From: Amanda Scholes on behalf of Planning.Responses
Sent: 01 February 2018 09:46
To: Planning Scanning
Subject: FW: Sheffield Stand design details P/1/18/DOC

Final Highways comments

From: Simon Davis [REDACTED]
Sent: 31 January 2018 10:06
To: Paul Spratt
Cc: 'Tim Townsend'
Subject: RE: Sheffield Stand design details

Cycle store for individual properties without garages

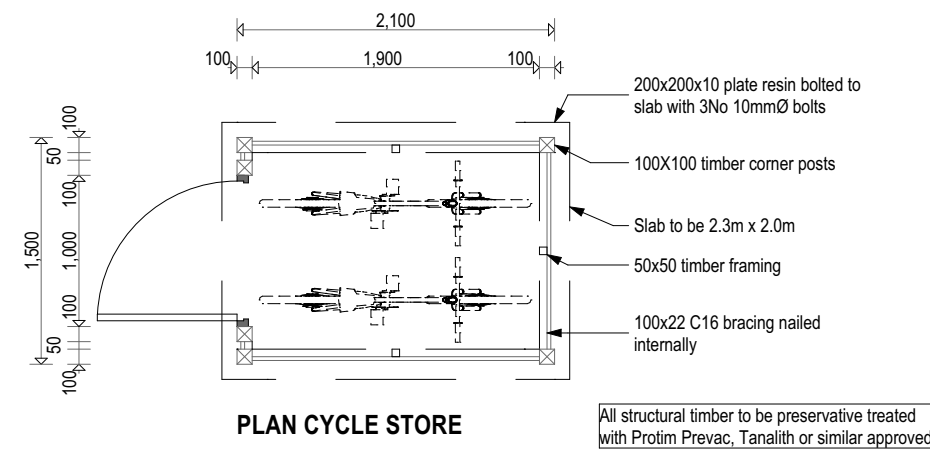
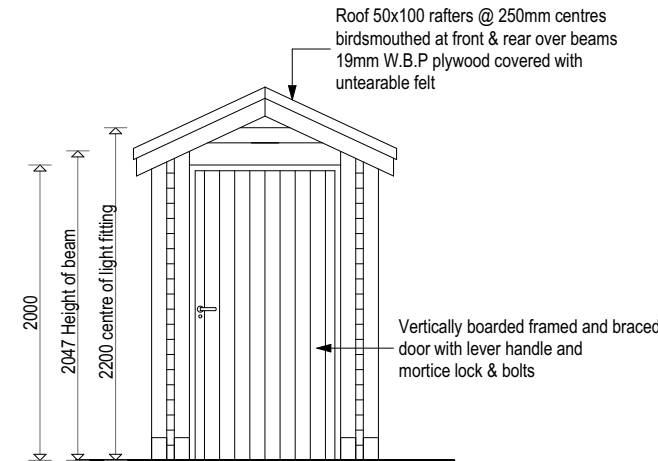
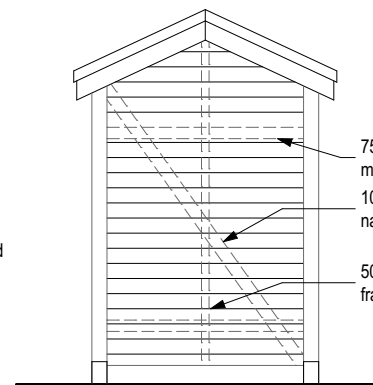
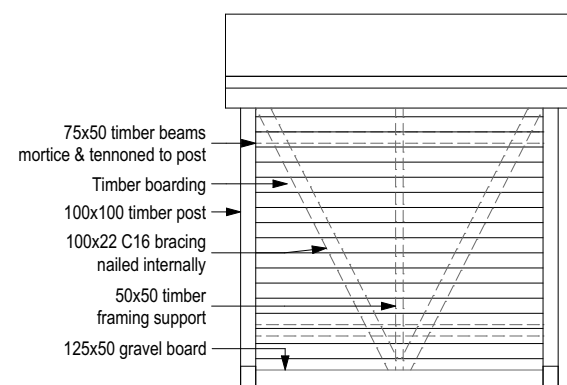
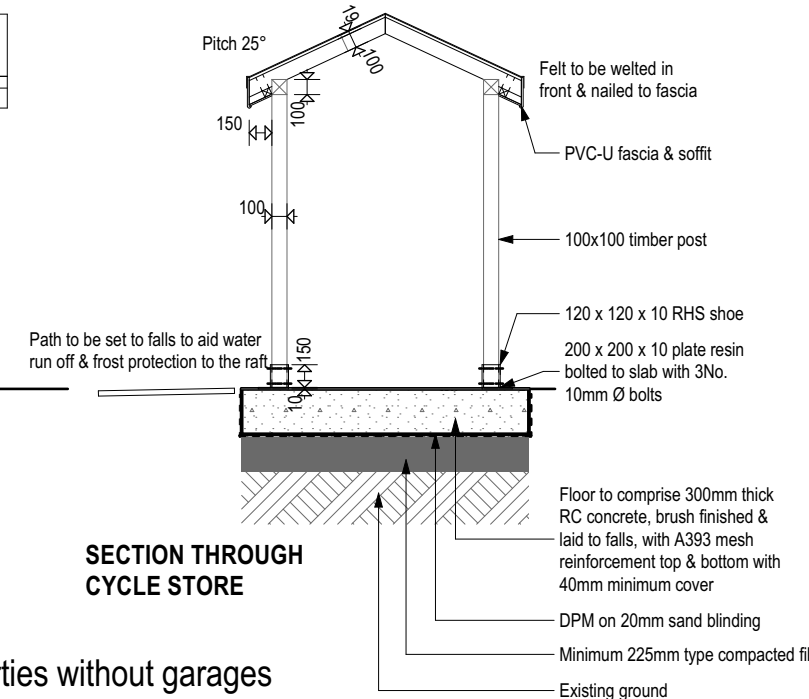
I have discussed with my Team Leader and we do not consider that the building can be enlarged as it would deviate from the size shown on the approved planning layout and the size increase could not be considered as an NMA. Therefore, we will allow the compromise option 2 which although slightly larger is within NMA tolerances.

Please provide the drawing (plan & elevations for the option 2 design) so these can be added to the file.

Both – this is acceptable to WSCC Highways.
